# City of Albuquerque Stormwater Construction Site Inspection Report

General Information					
Project Name:	Valle de Atrisco				
Location:	9901 Ceja Vista Rd SW				
Site Contact Name & Agency	Trevor/ Trevco Inc.	ESC File No.	P09E002D		
	505-2386215	NPDES Id. No.	NMR1001TV		
Inspection Date:	02/25/19	Start/End Time:	0815/0900 hrs		
CoA Stormwater Inspector:	Timothy Sims, Stormwater Inspector				
Present Phase of Construction:	Foundations, footings				
Type of Inspection:	<input checked="" type="checkbox"/> Regular	<input type="checkbox"/> Storm Event	<input type="checkbox"/> Post Storm Event >0.25"	<input type="checkbox"/> 311/Complaint	<input type="checkbox"/> Follow Up

VALLE DE ATRISCO
EROSION & SEDIMENT CONTROL PLAN

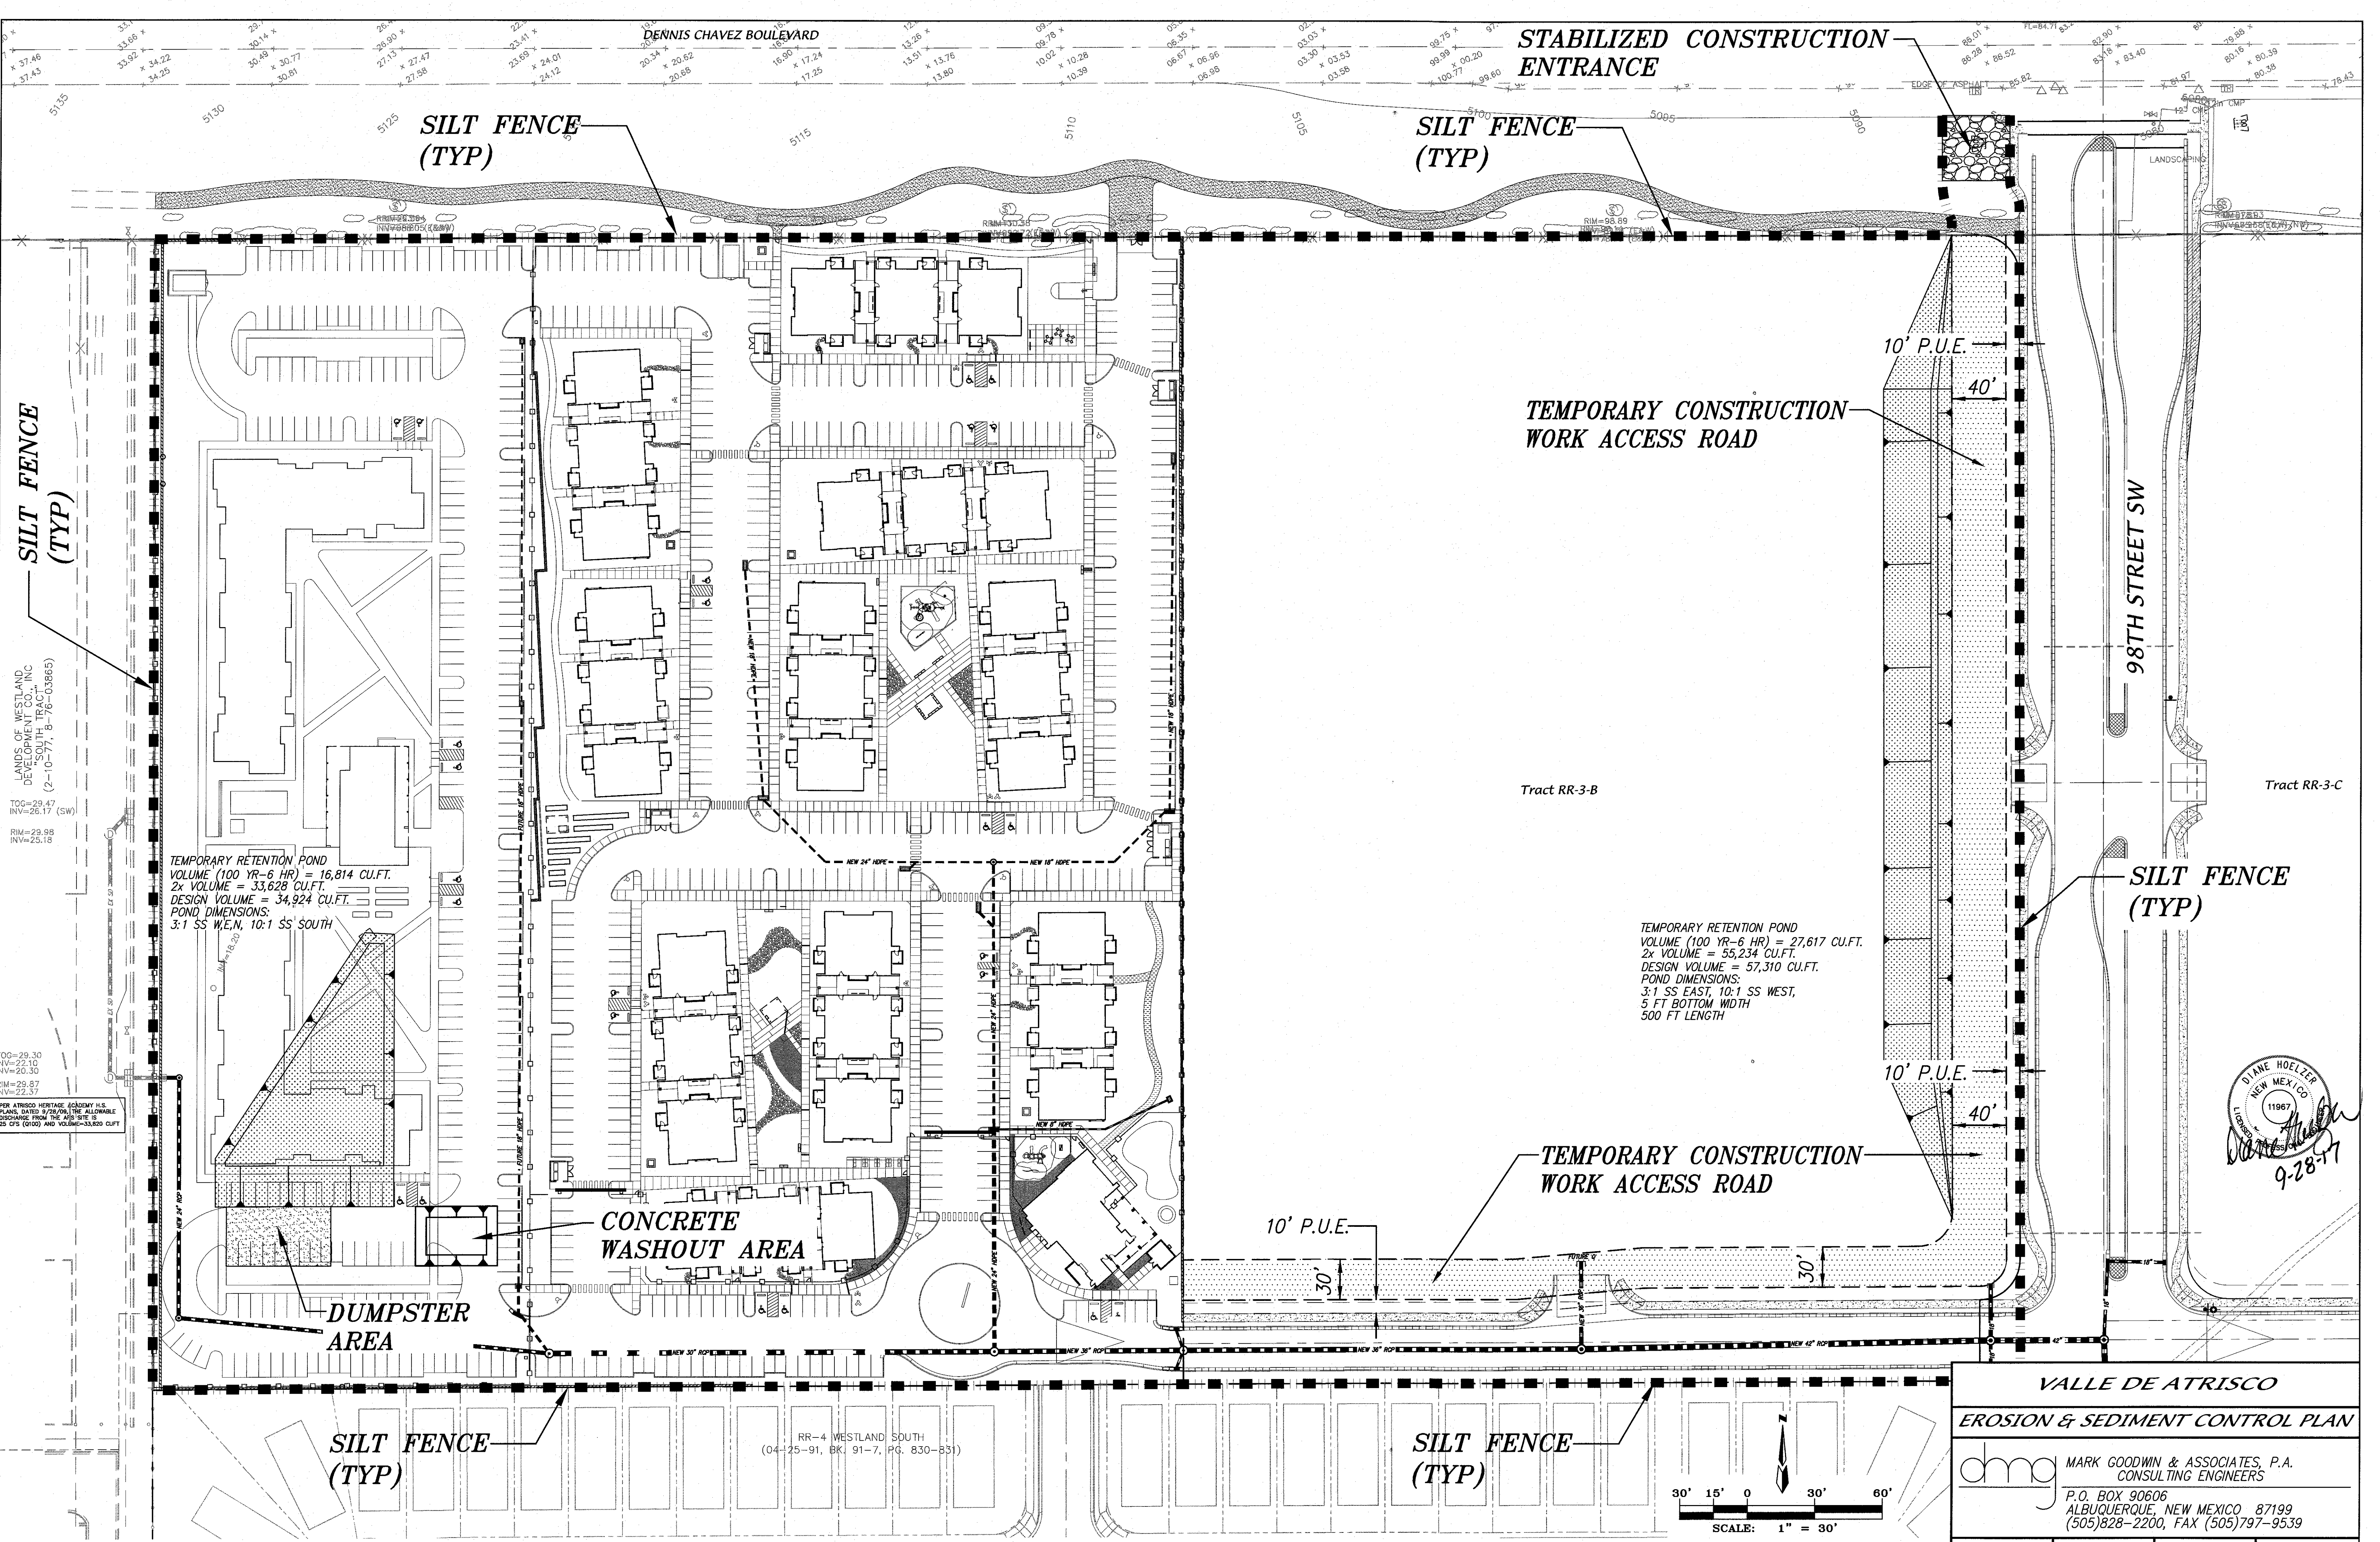
2.2.3	Sediment control along any perimeter	x	East silt fence needs maintenance, cleaning
2.2.3	Sediment control along any perimeter	x	Repair silt fence as needed

Maintenance or corrective actions are to be completed within seven (7) days.
